Subject: Planning Consultation on: BR/201/20/PL

Application No: BR/139/20/PL

Site Address: 29 Highcroft Crescent Bognor Regis PO22 8DH

Description of Works: Re-establishment of dwelling to form former pair of semi-detached bungalows.

Proposed

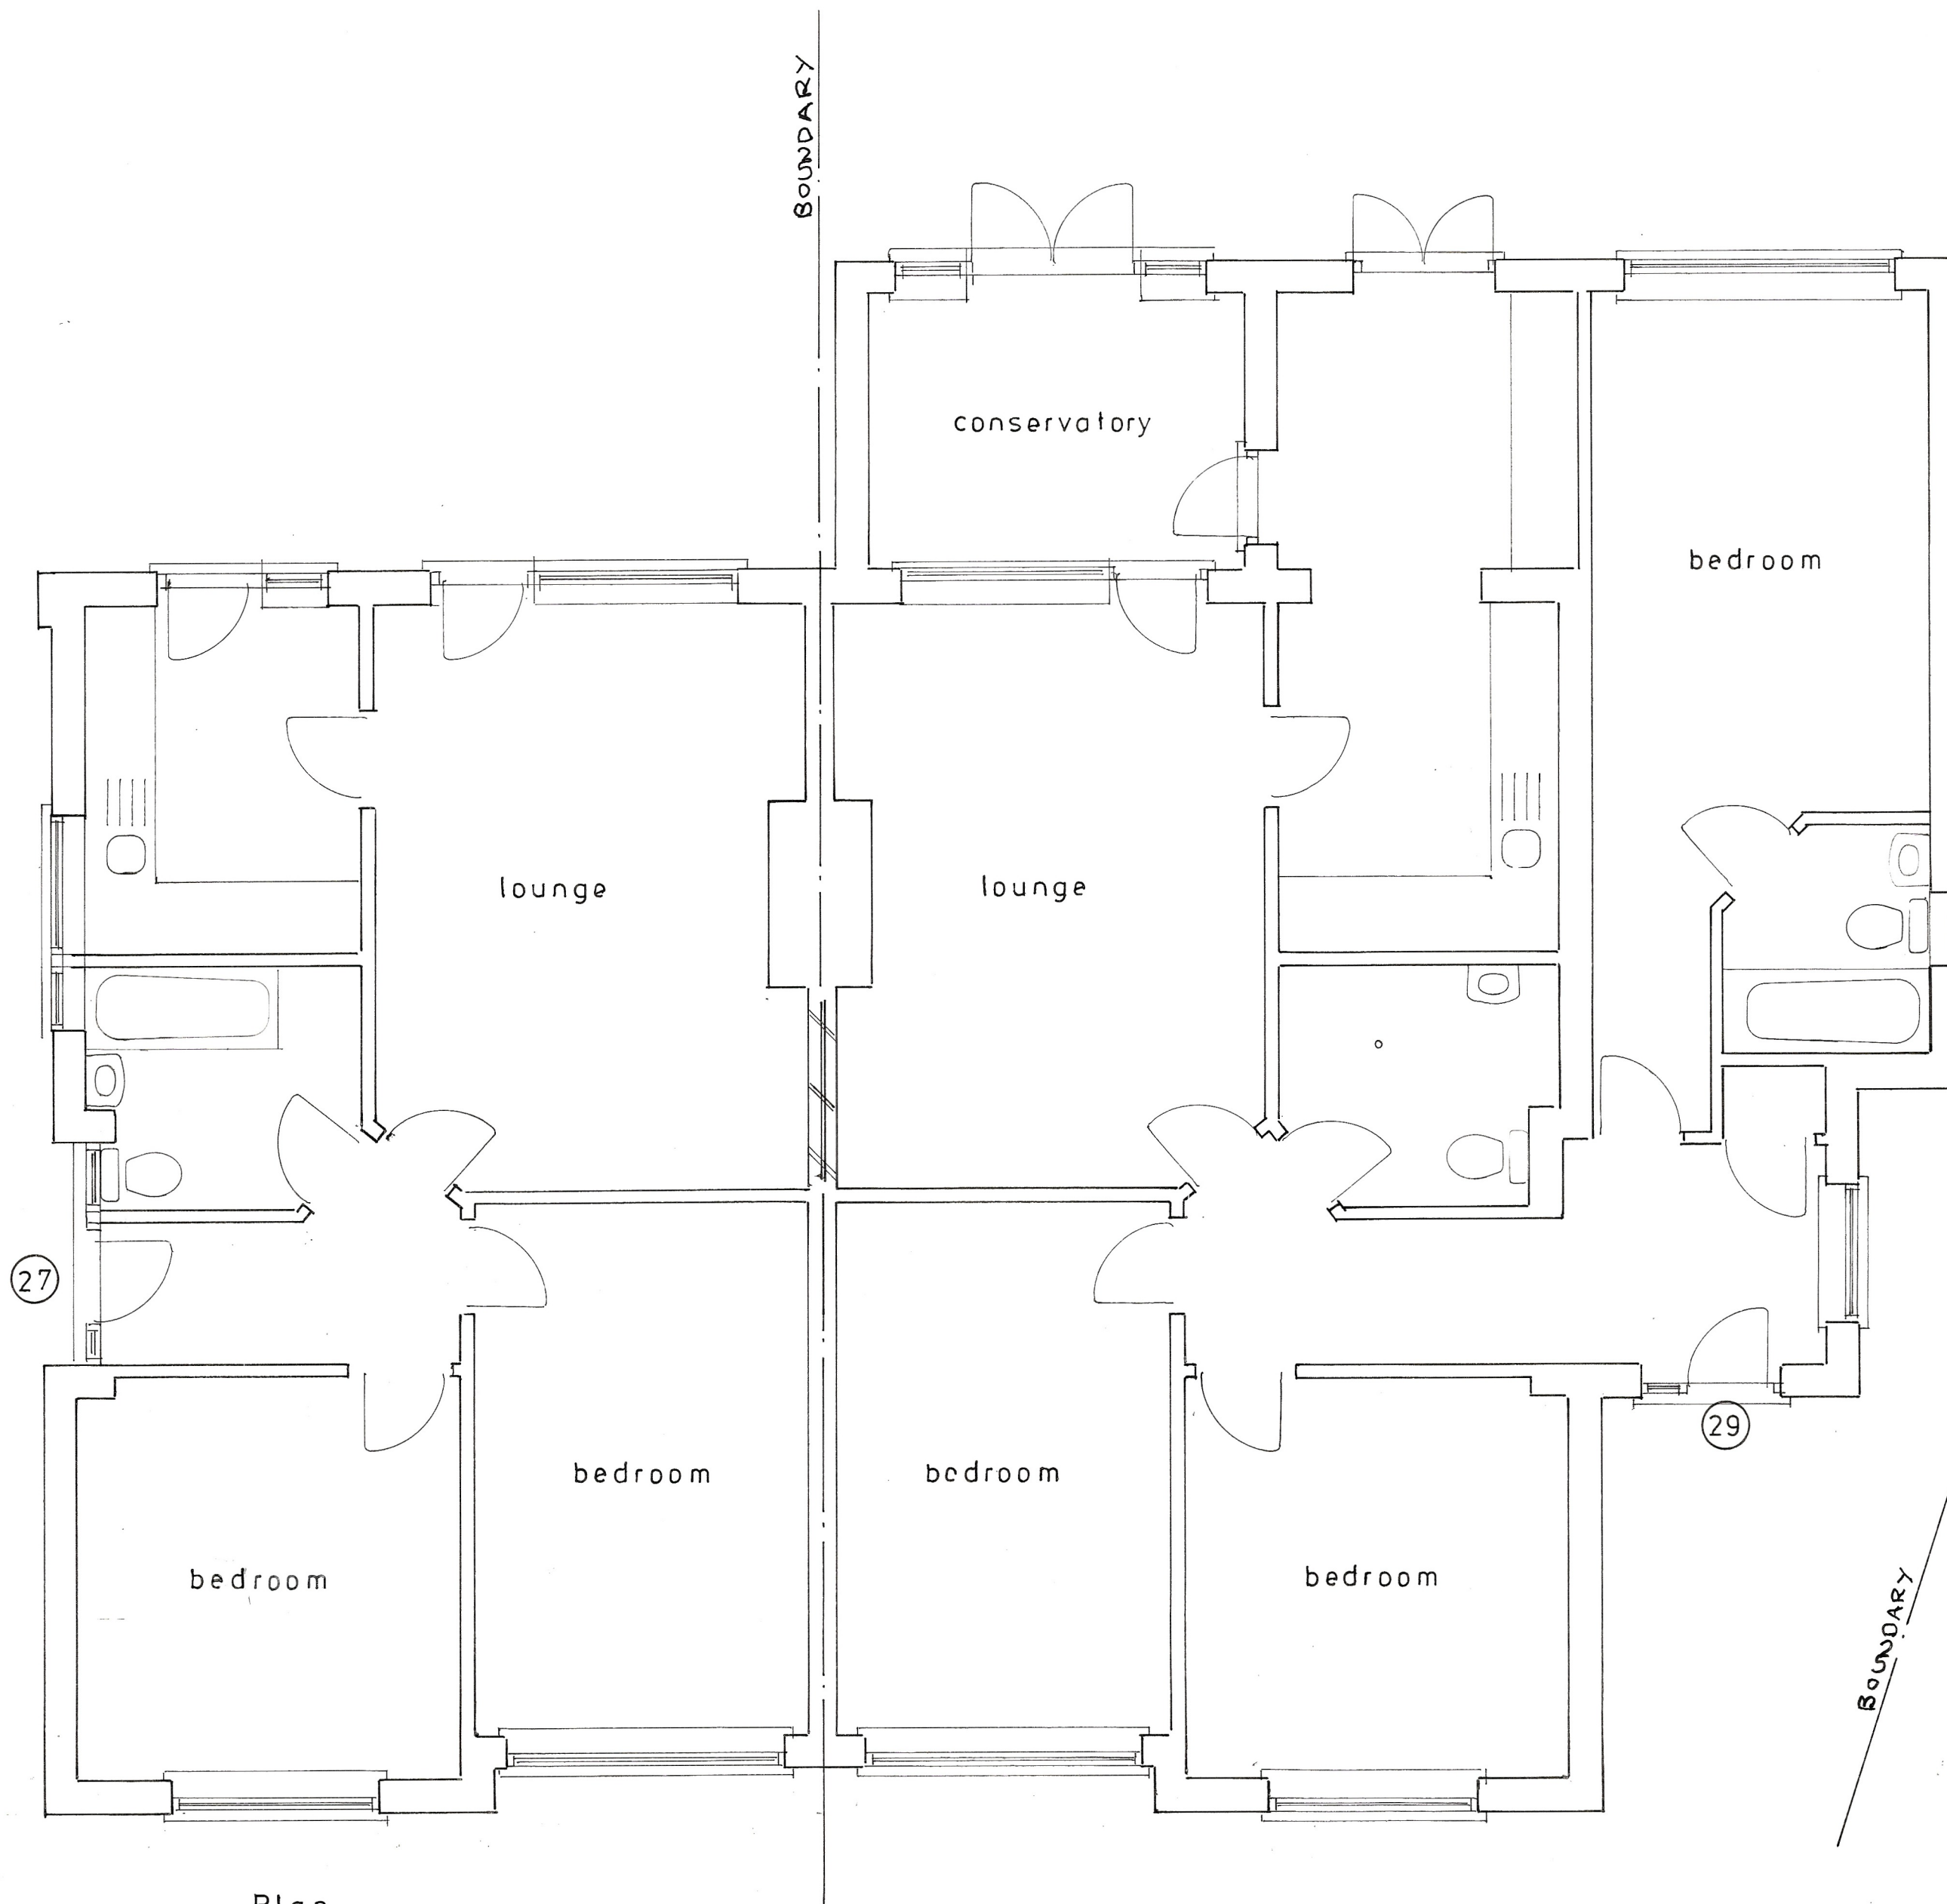
- There does not appear to be a bath or shower present within the shared bathroom in number 29; it appears there is only a bath present within the en-suite bathroom contained within one of the bedrooms. It is likely this has just not been included within the plan, but for clarification, a bath/shower should be provided to the shared bathroom
